Memo

Subject: N6-2010-2055-MA – Former Shredded Wheat Factory, Broadwater Road, WGC

4.3 Civic Square

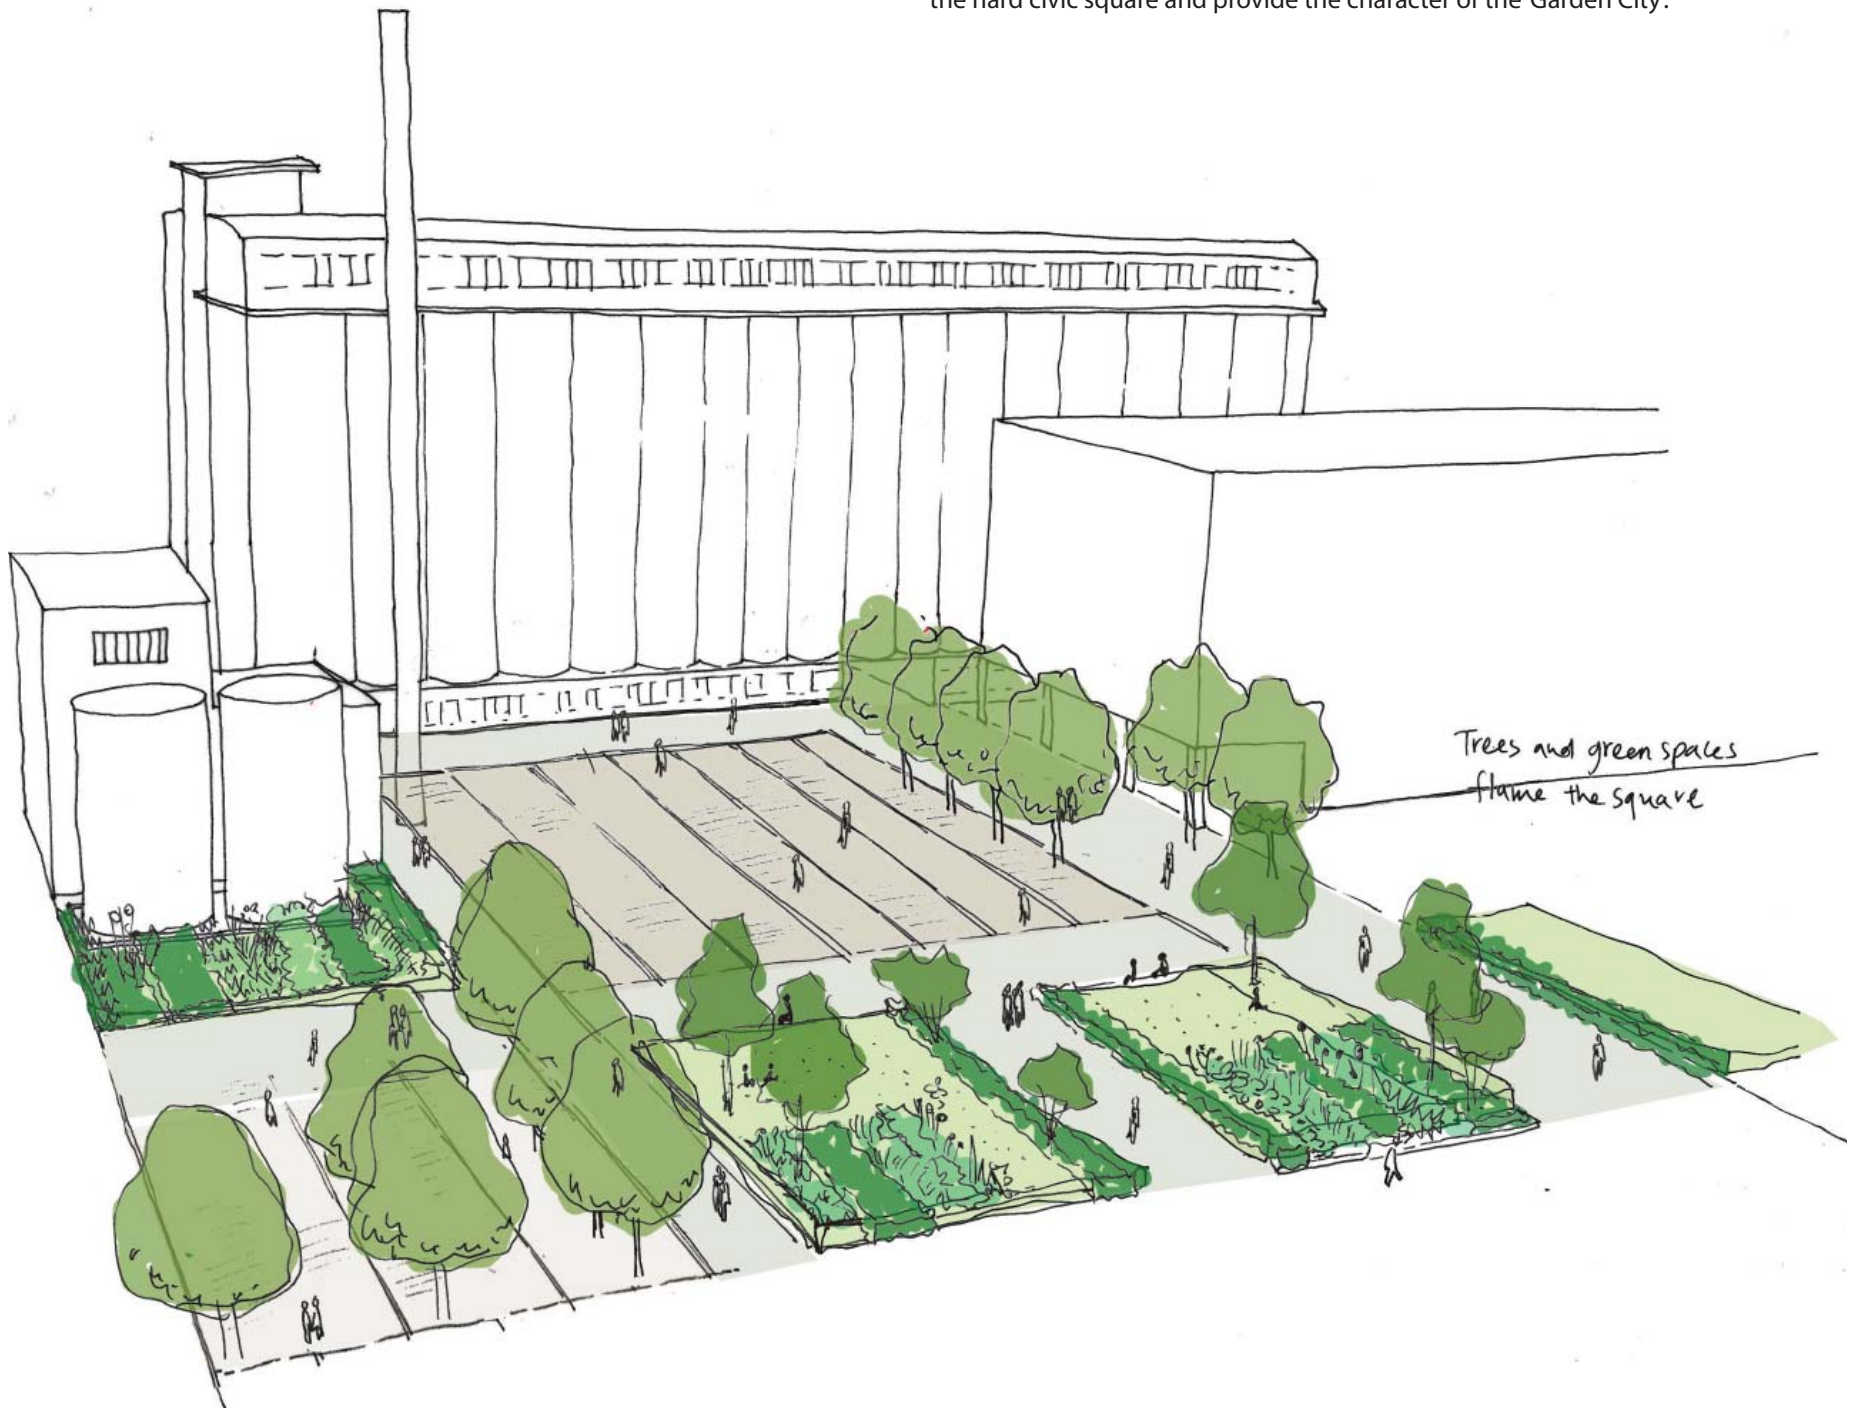
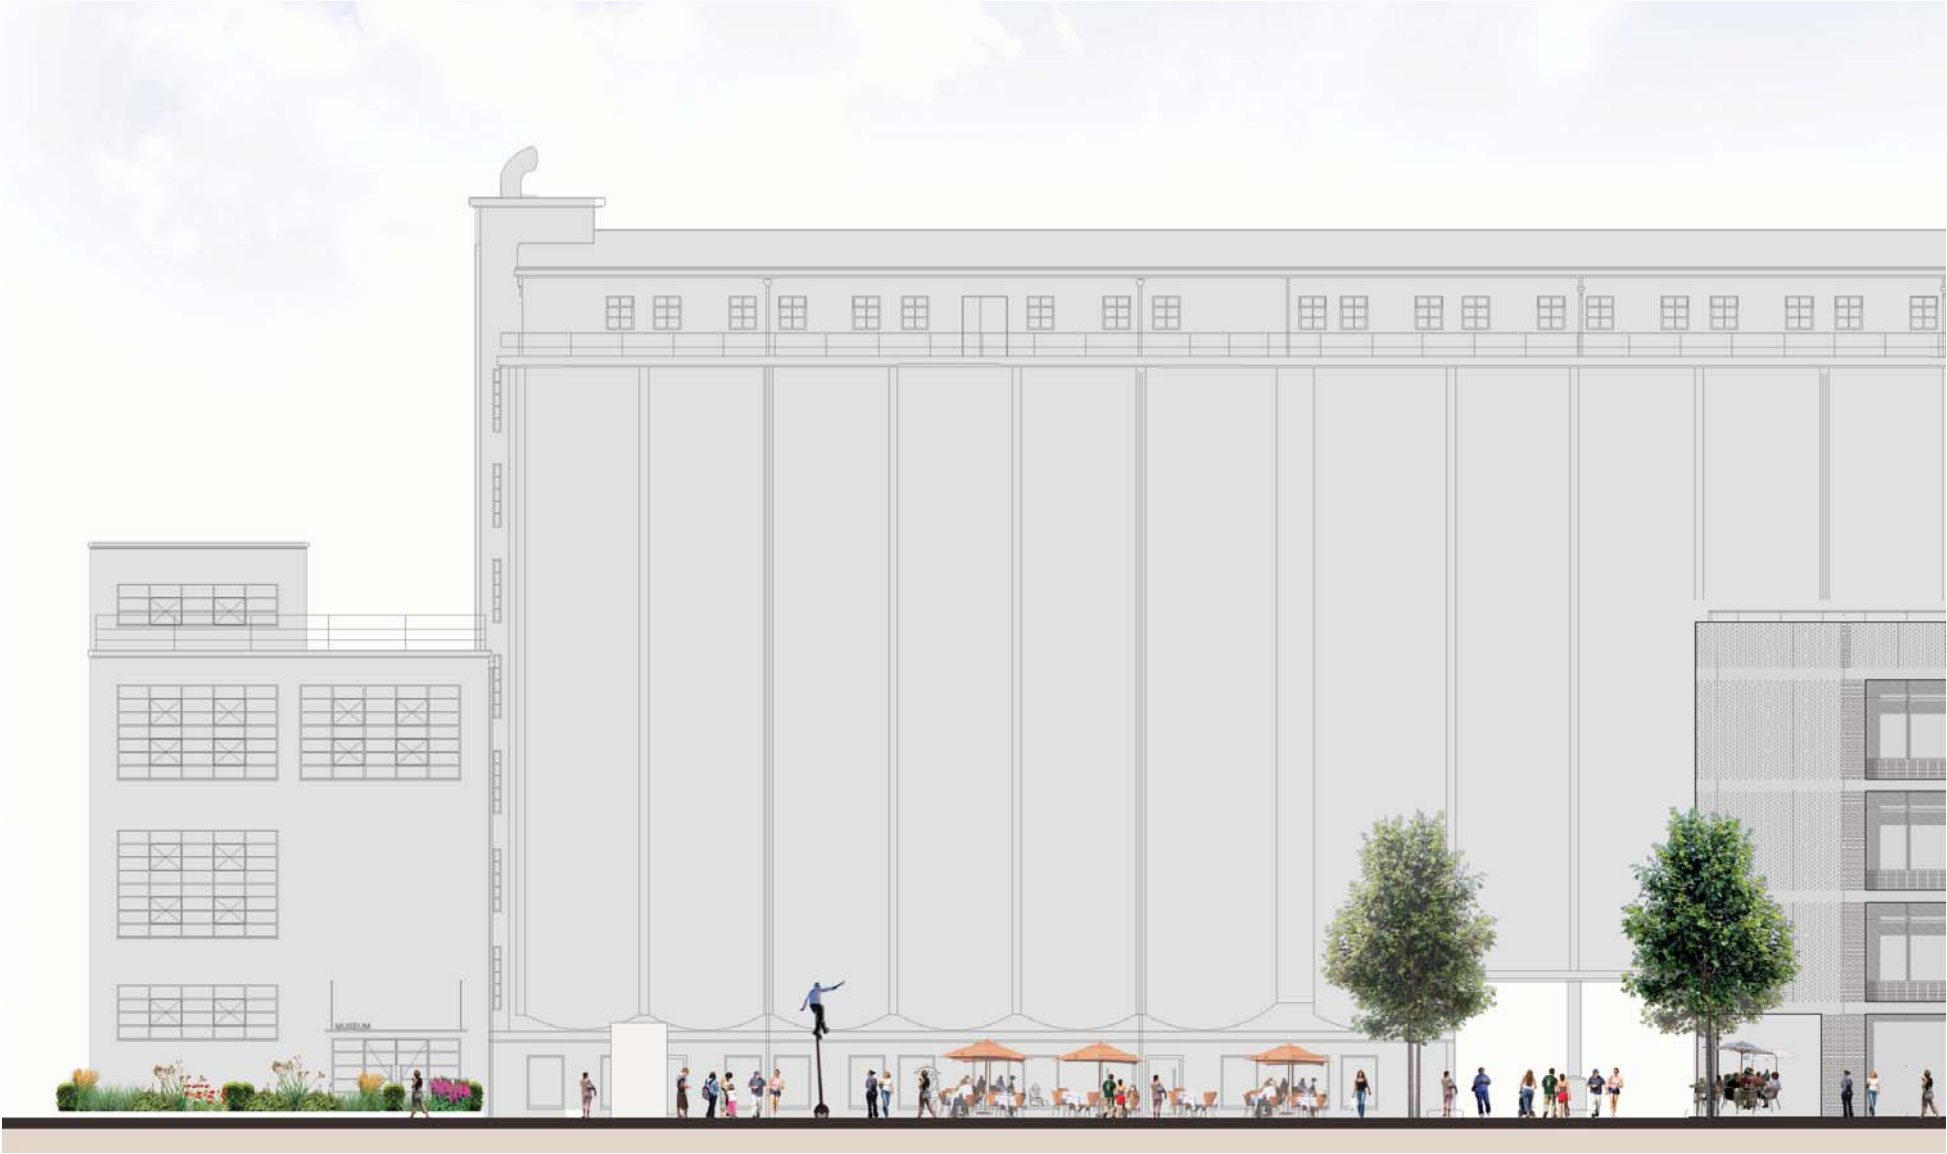
The more mixed planting around the Civic Square is good and in this more sheltered position, the use of *Quercus palustris* could be successful. It is not clear to me however why the whole area needs to be paved and why a large planting bed could not be created to house the four *Quercus palustris* and soften the area here.

Detail 1.03
Tree pit on slab

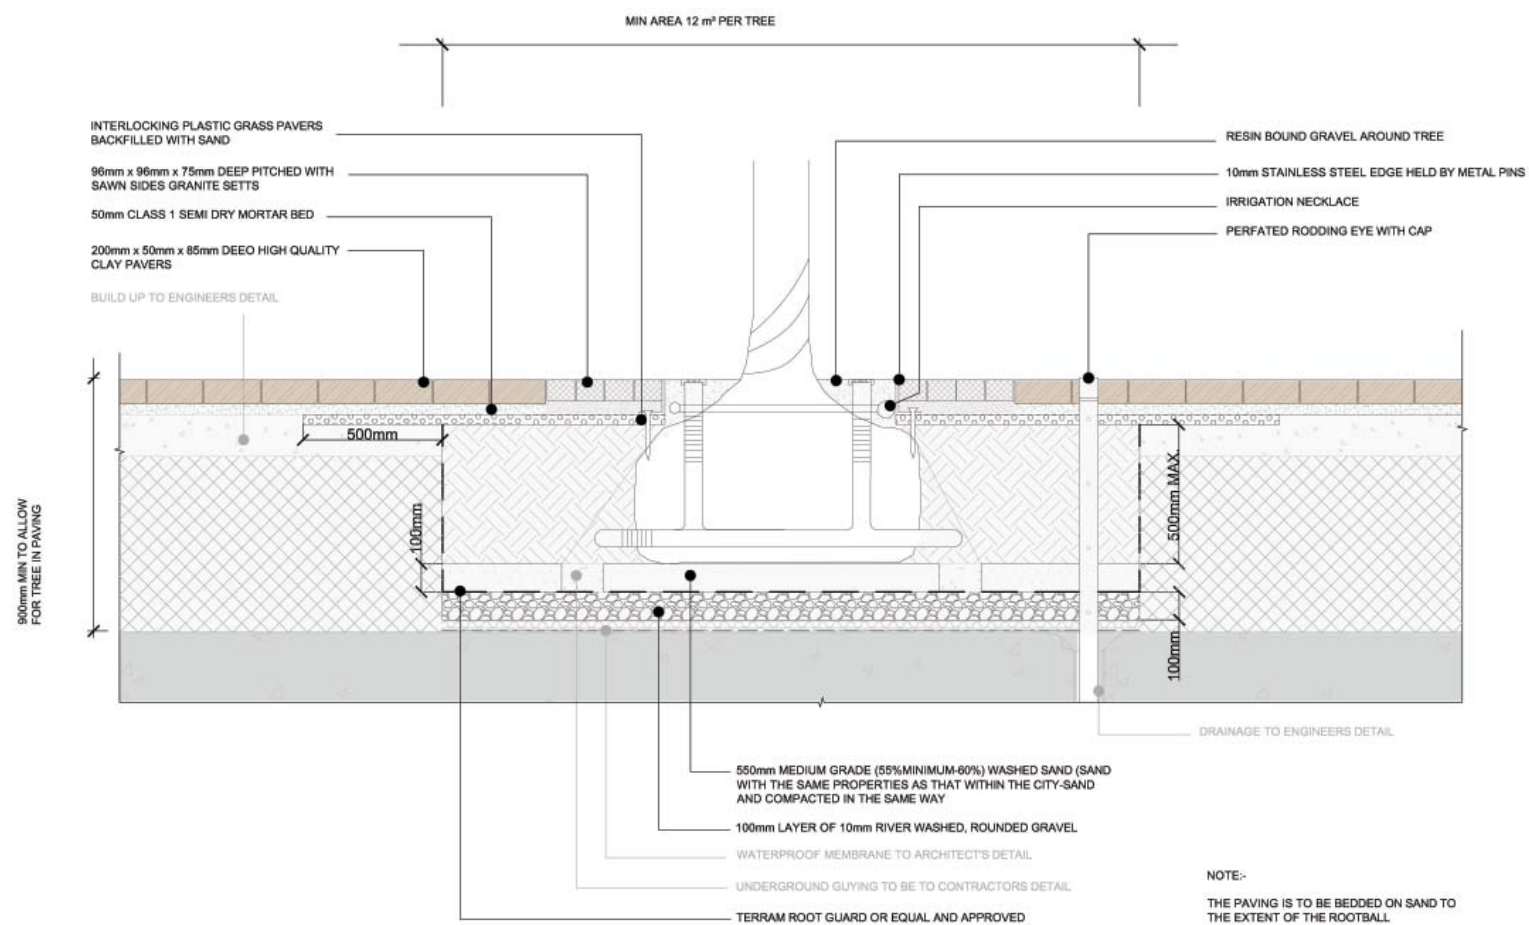
To the side of the leisure centre the trees that are shown to be planted here are wedged into the middle of the parking area. From experience this type of planting seldom results in a thriving tree, as the conditions are just too tough. I could see no mention of design of planting pits and this would be essential for any scheme going forward. For any trees that are to remain with their mature root systems predominately under hard standing the applicants would need to provide details of underground frameworks such as Silva Cell with structural soils. Again the species chosen here is *Tilia cordata* which will drip honeydew onto all the parked cars and this should be altered to a resistant variety.

To the rear of the leisure centre is a set of *Pyrus Chanticleer* which is acceptable but as this area is shown to be asphalt with stone chippings the trees need to have underground frameworks and the surface needs to be permeable.

6.2 Tree Planting

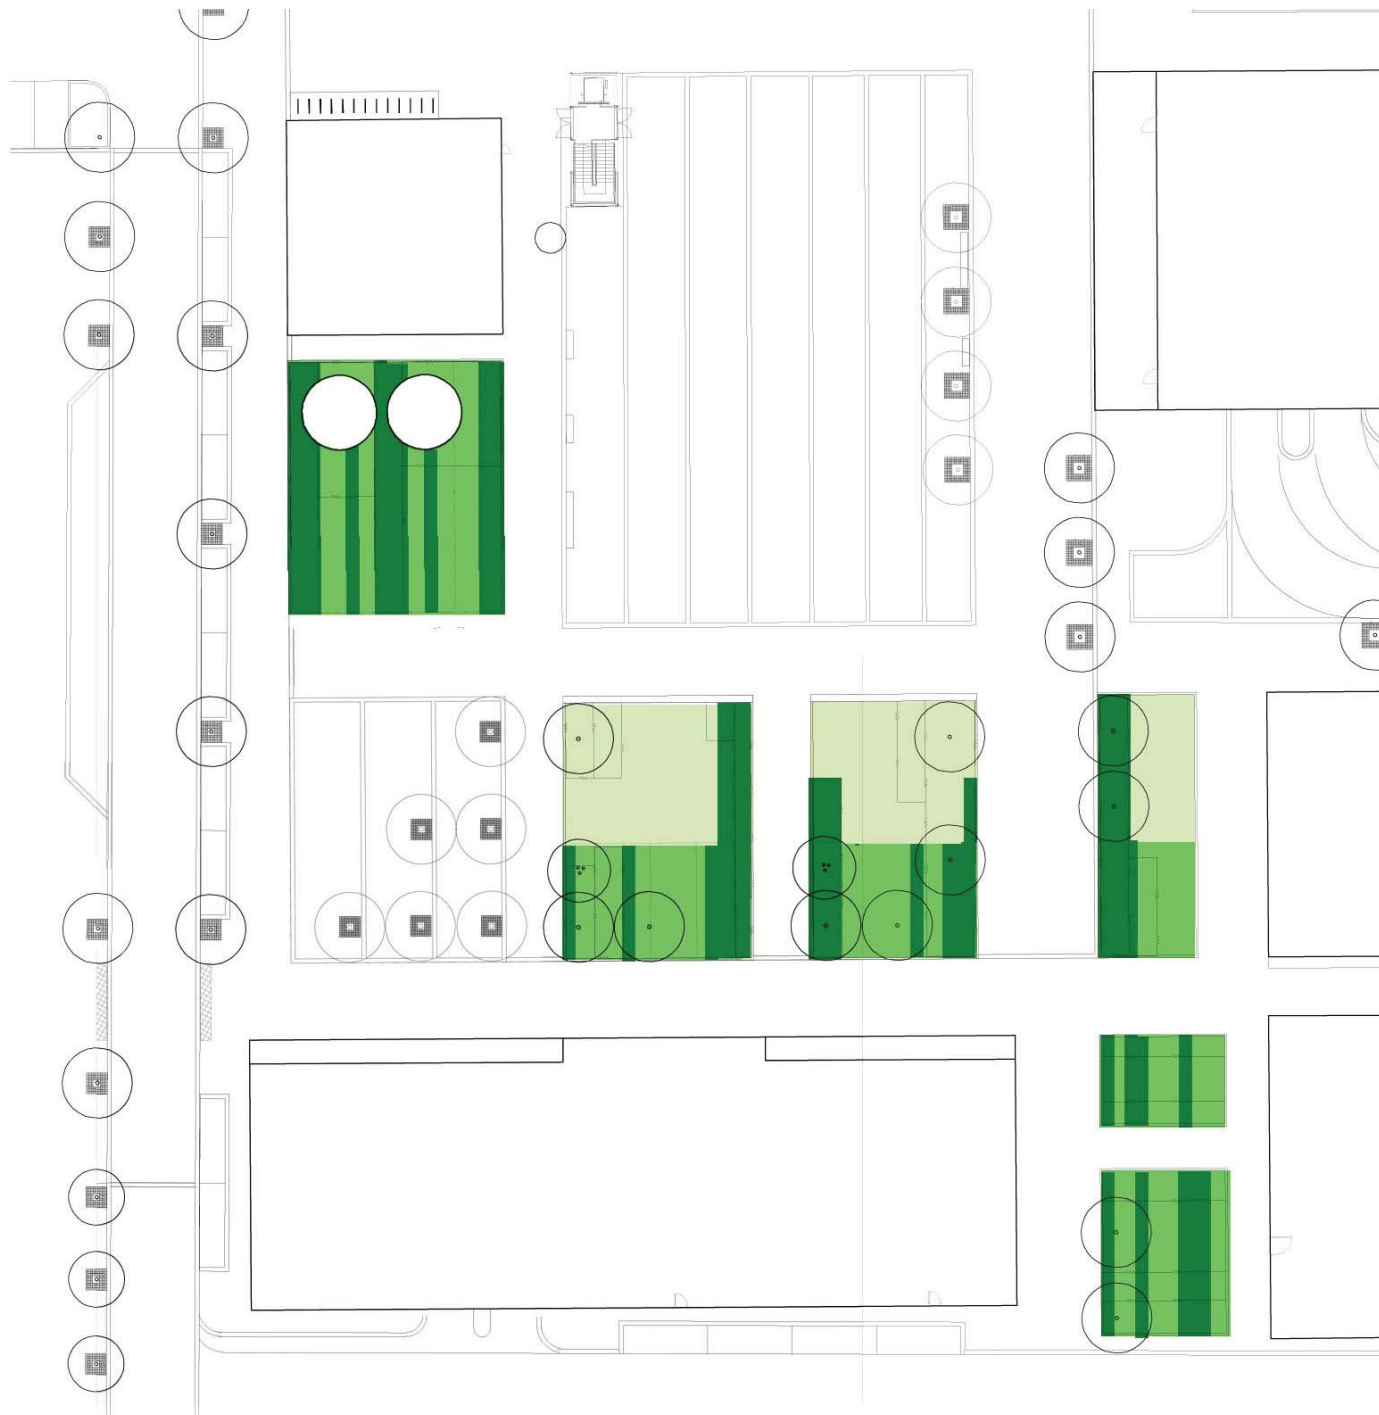
The proposed new planting is as a whole beneficial to the site. However there are areas where it could be improved upon in terms of species and location. The proposed planting plan mistakenly lists the dark green trees as *Quercus palustris*, when according to the picture key they are *Pyrus Chanticleer*. I will assume they mean *Pyrus* for this purpose. Also their own environmental statement details a list of trees that they will plant on site for ecology purposes, none of which actually feature in the proposed planting.

To start with the replacement trees chosen for the two sycamore removed to widen the road are *Quercus palustris*. They have been shown at very close spacings in a very small verge area, barely wide enough to plant in. *Quercus palustris* are generally sensitive and difficult to establish and along a main trunk road in the town I feel would be too harsh for this species. It would be better to use *Acer campestre* here as this is a hardy, robust species that establishes well in this borough. Although less ornamental, i feel it would be more appropriate.

Moving down Broadwater Road to the replacements for the fastigiata Oaks which they need to remove to widen the road, they have proposed to replace with *Pyrus Chanticleer*. This would not be acceptable as this set of trees extends down both sides of Broadwater Road and needs to be replaced with *Quercus robur* *Fastigiata* *Koster*.

The formal lines of Lime trees around doctors surgery area are fine, but i would caution against the use of *Tilia cordata* which attracts aphids, and therefore the dripping honeydew that is sticky and messy in the summer months. There are varieties that are resistant to aphids and these would be more advisable.
